Rezoning Transportation Analysis

Petition Number: 2020-124

Revision Log:

Date	Description
09-14-20	First Review

**RZ-1.0**

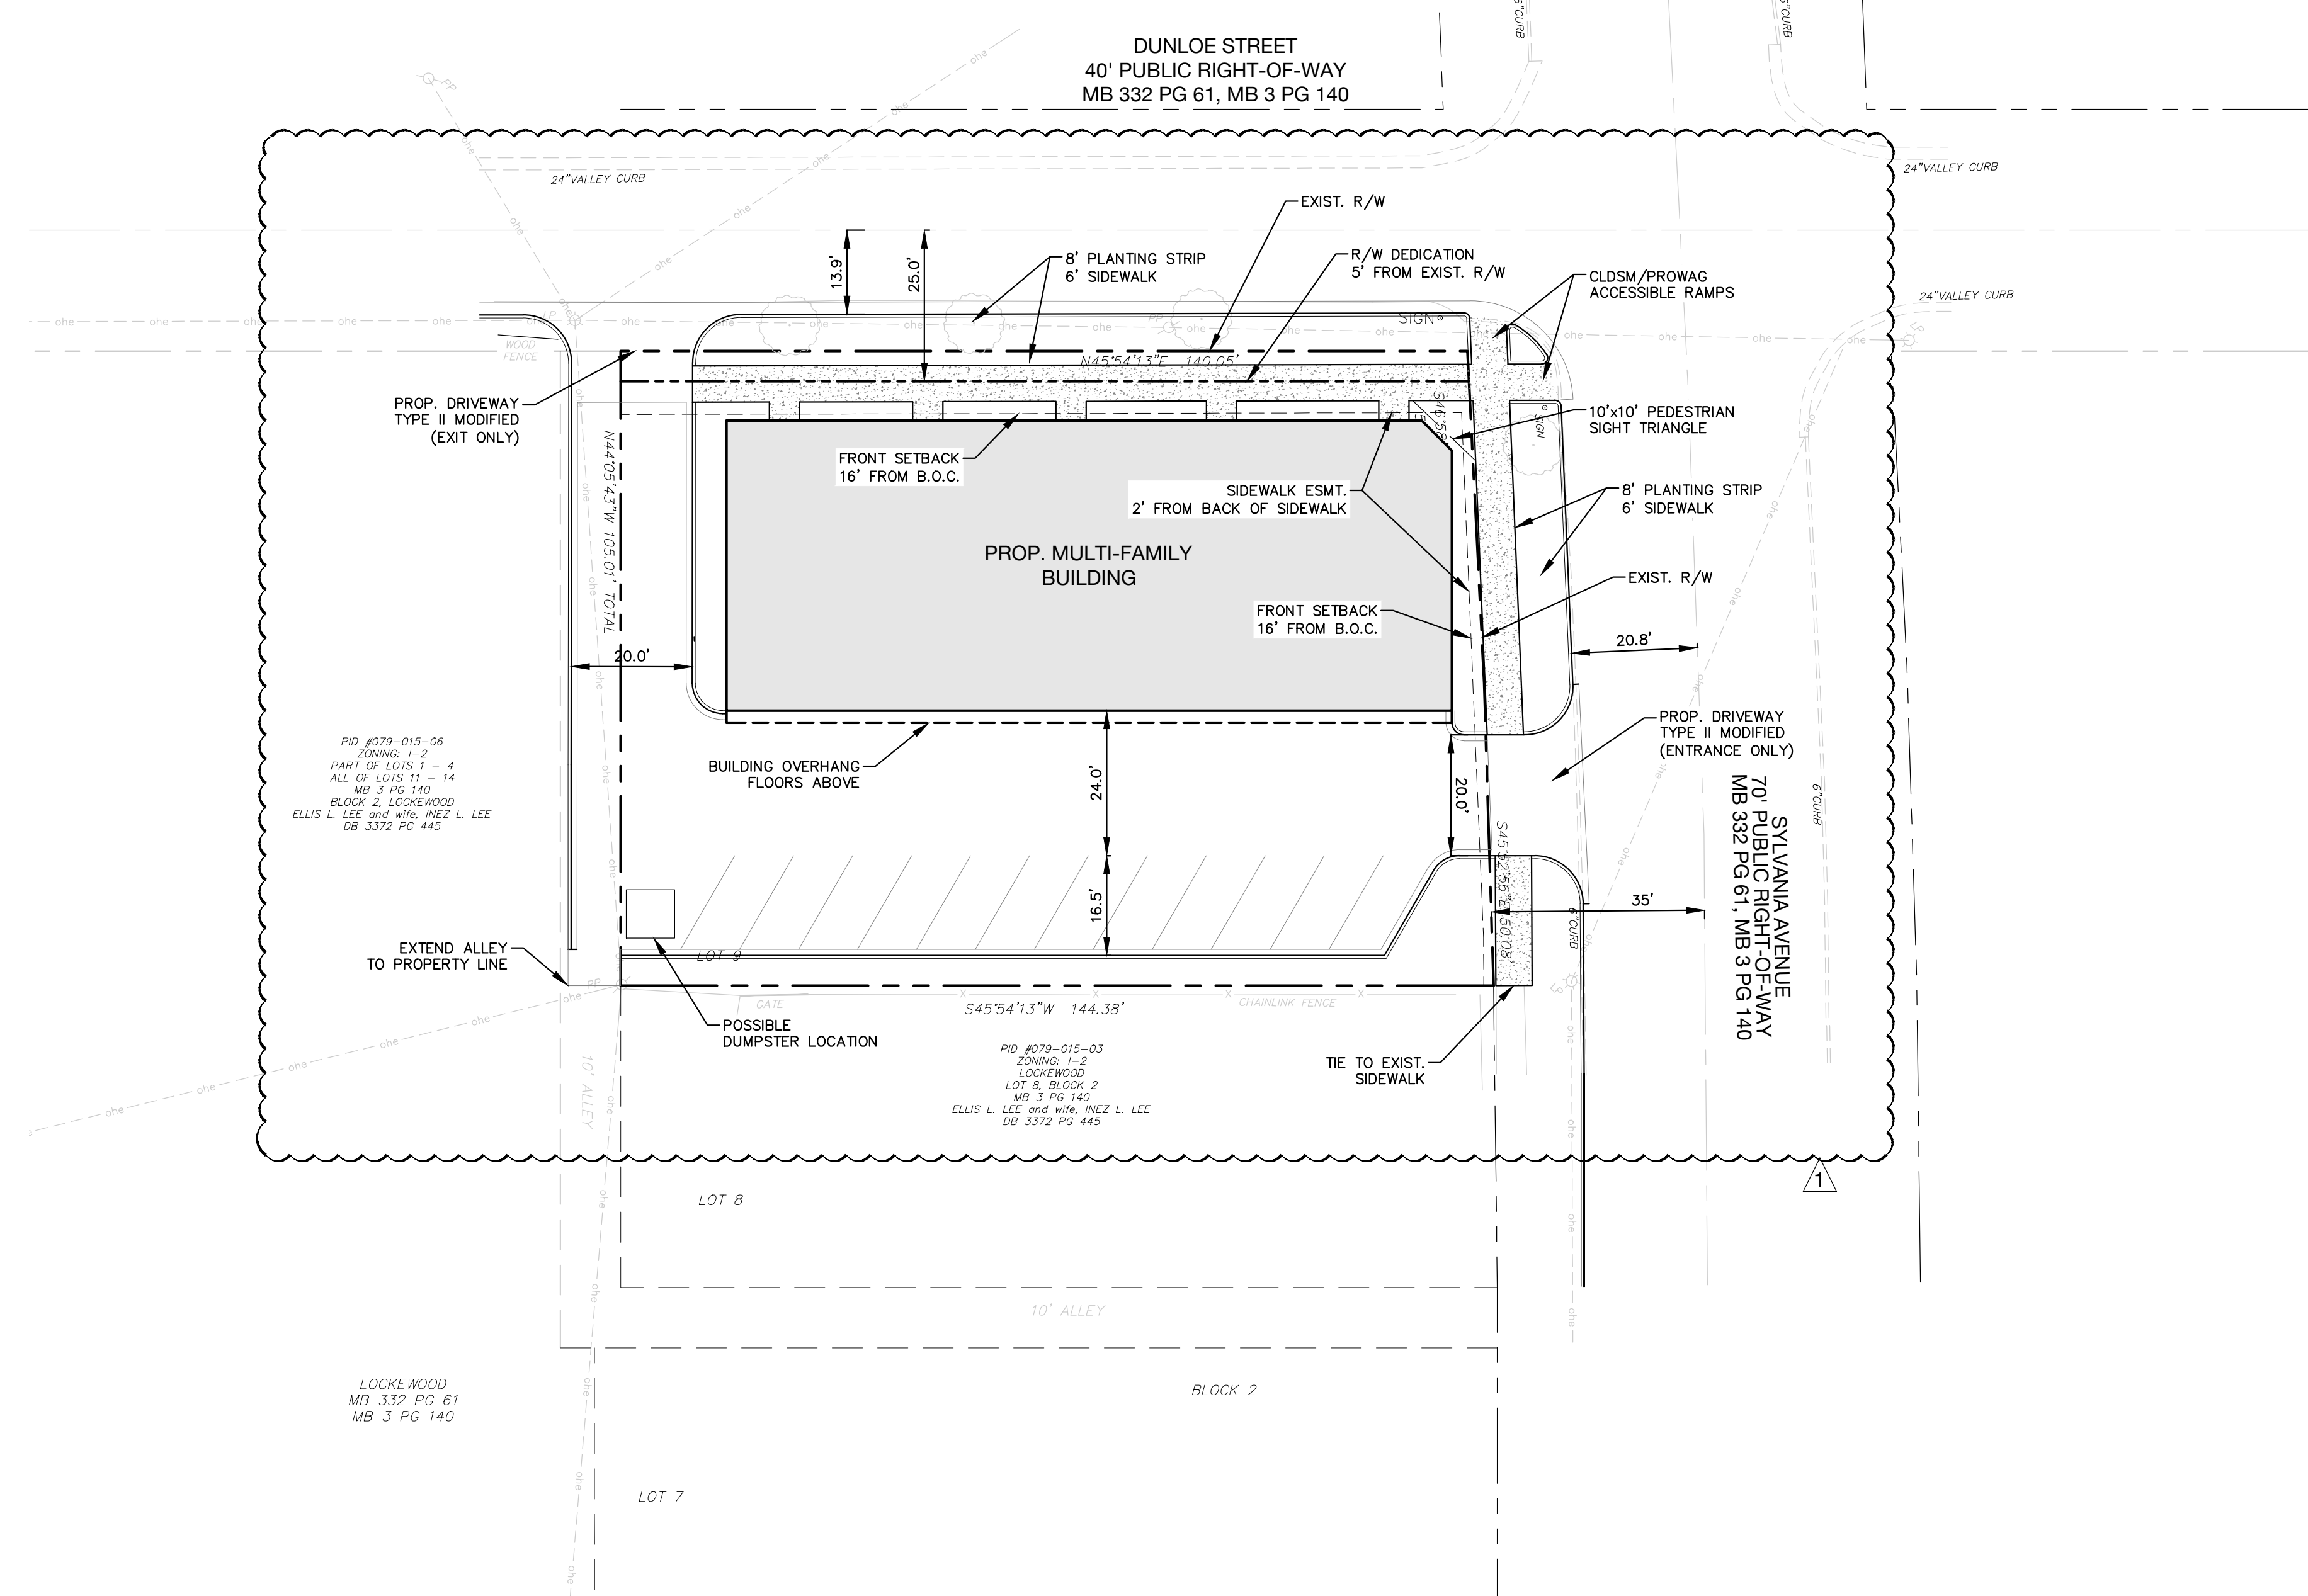
Label and dimension the curb and gutter from the centerline for each road.

- Traffic Study** A Traffic Impact Study is not necessary for the complete review of this petition. If during the permitting process the site generates more than 2,500 daily trips, then a traffic study will be required.
- Revise the site plan and conditional note(s) to commit to install two CLDSM and PROWAG standard accessible ramps at the Dunloe Street and Sylvania Avenue intersection location, shown below.

- Revise the site plan and conditional note(s) to confirm the proposed building footprint does not encroach within the pedestrian-approach intersection sight triangle, in conformance with CDOT's Sight Distance Policy. This triangle is measured from the back of the proposed sidewalk utility easement.

- Revise the site plan and conditional note(s) to provide a stub for future cross access within the existing alleyway.

6. Revise the site plan and conditional note(s) to reverse the proposed one-way traffic circulation, so the ingress movement occurs from Sylvania Avenue (the higher volume street), and the egress movement occurs onto Dunloe Street. This orientation is preferred as turning movement decisions are made from the higher volume road.
